Subject: 2022/91168 - 3 Paddock LBC

Sue Brooks
Senior Conservation Officer - Development Management
Planning & Development Service
Growth and Regeneration
Kirklees Council
PO Box 1720, Huddersfield HD1 9EL

Title
Proposed layouts and elevations.

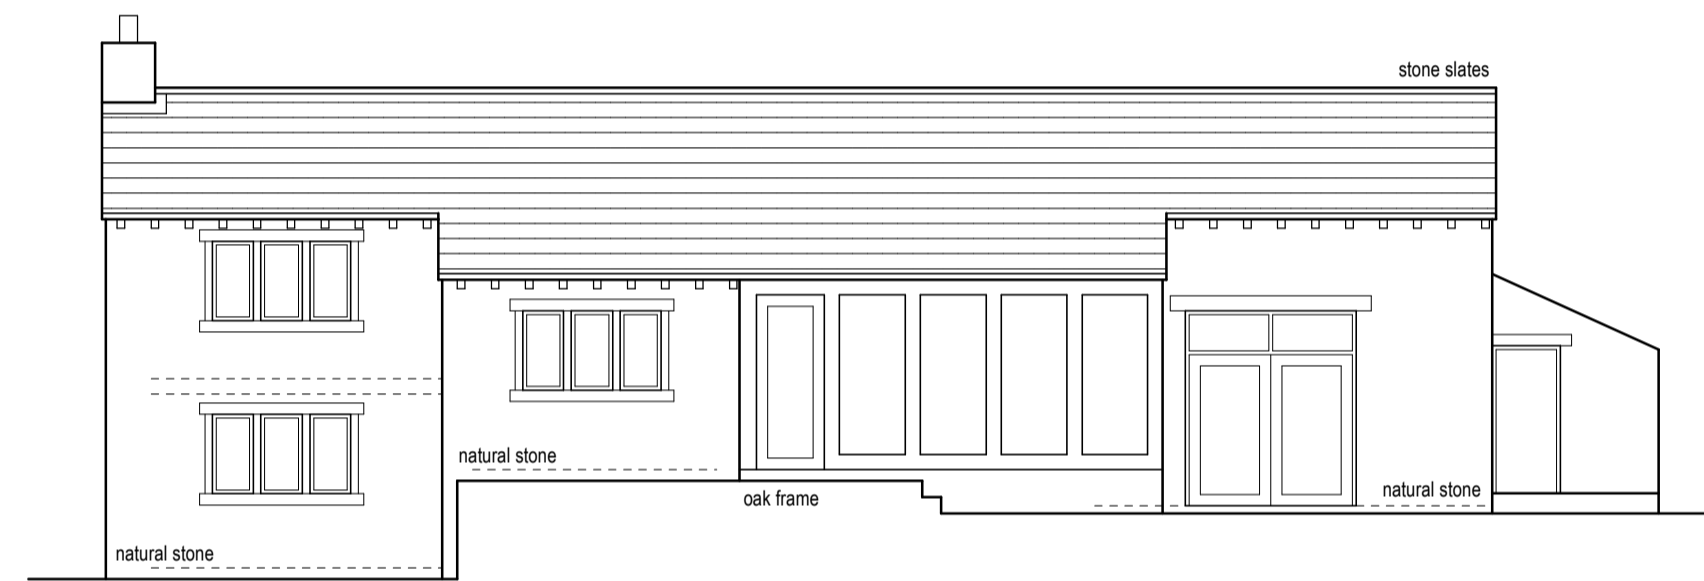
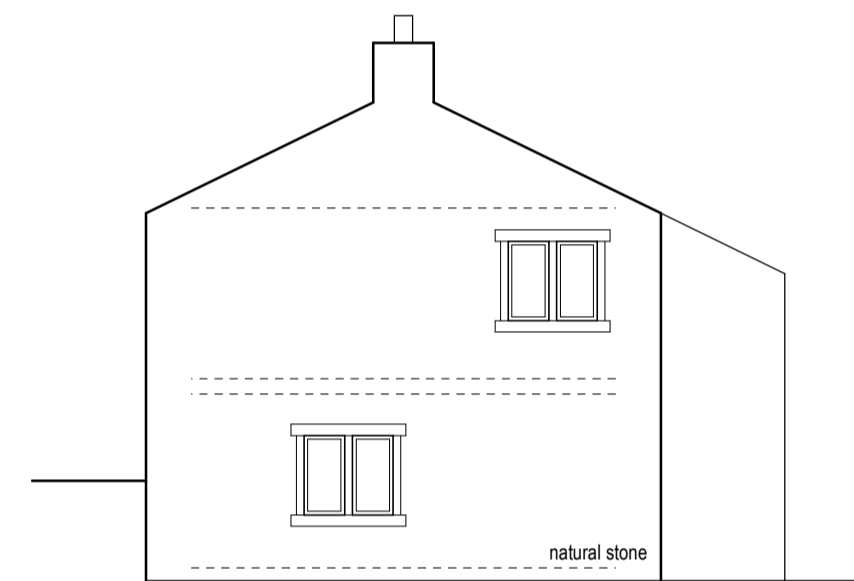
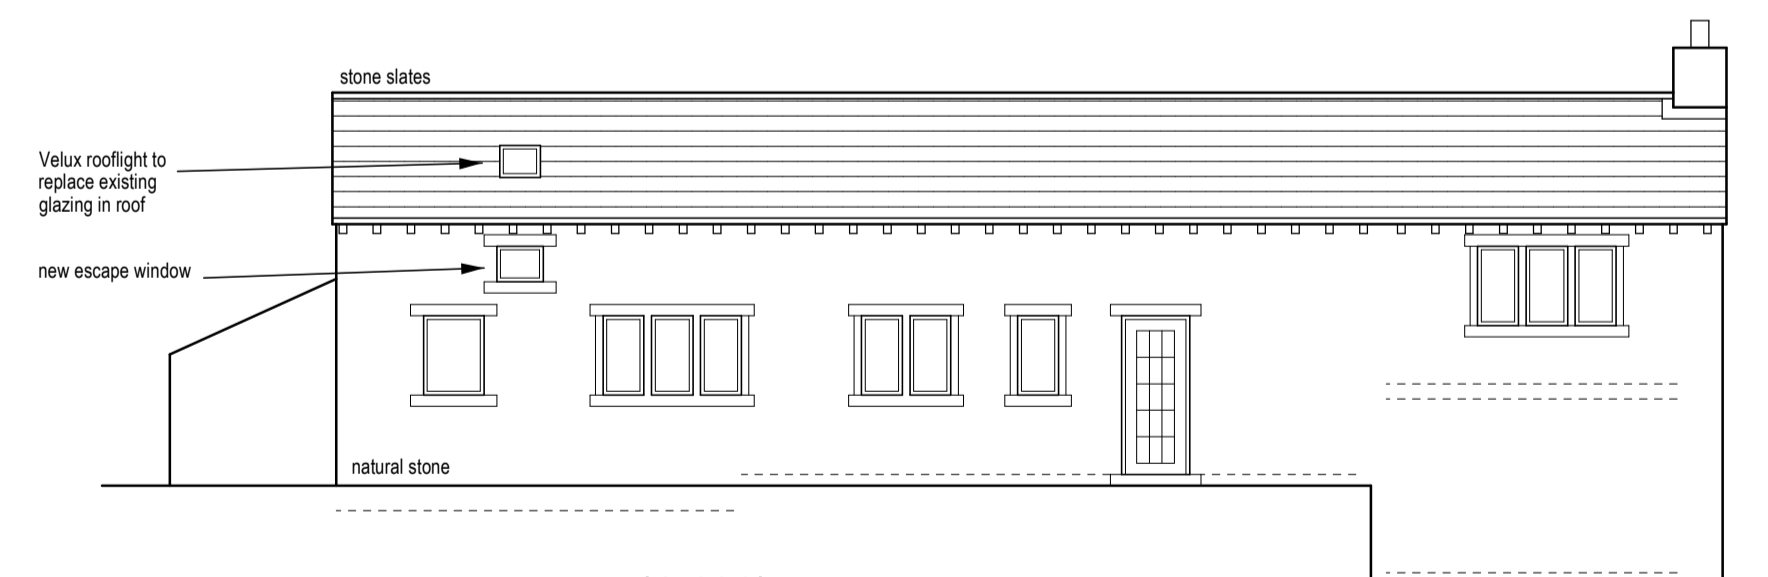
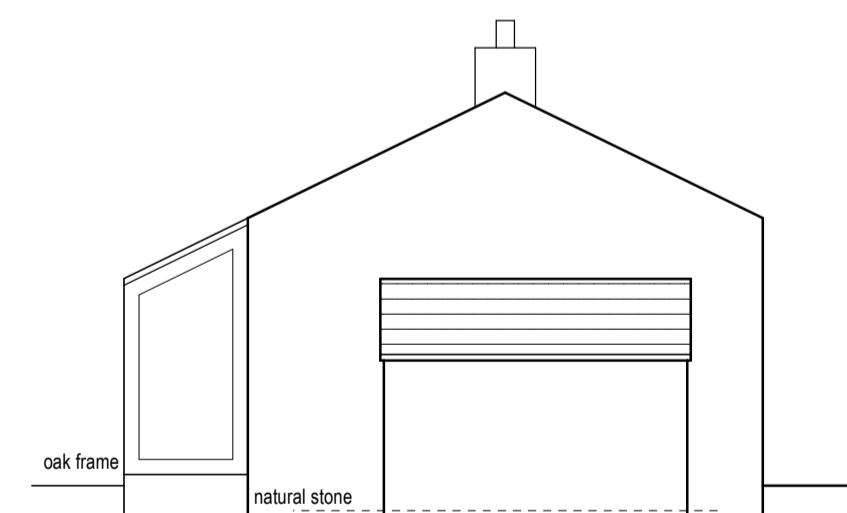
Based on the revisions discussed today, I would recommend that the south facing façade is retained without any further alterations as this will cause additional harm to the character of the former laithe house by further eroding the historic form of the building. A simple stone built single storey side extension on the west gable may be a more suitable option if there are no historic architectural details in this location.
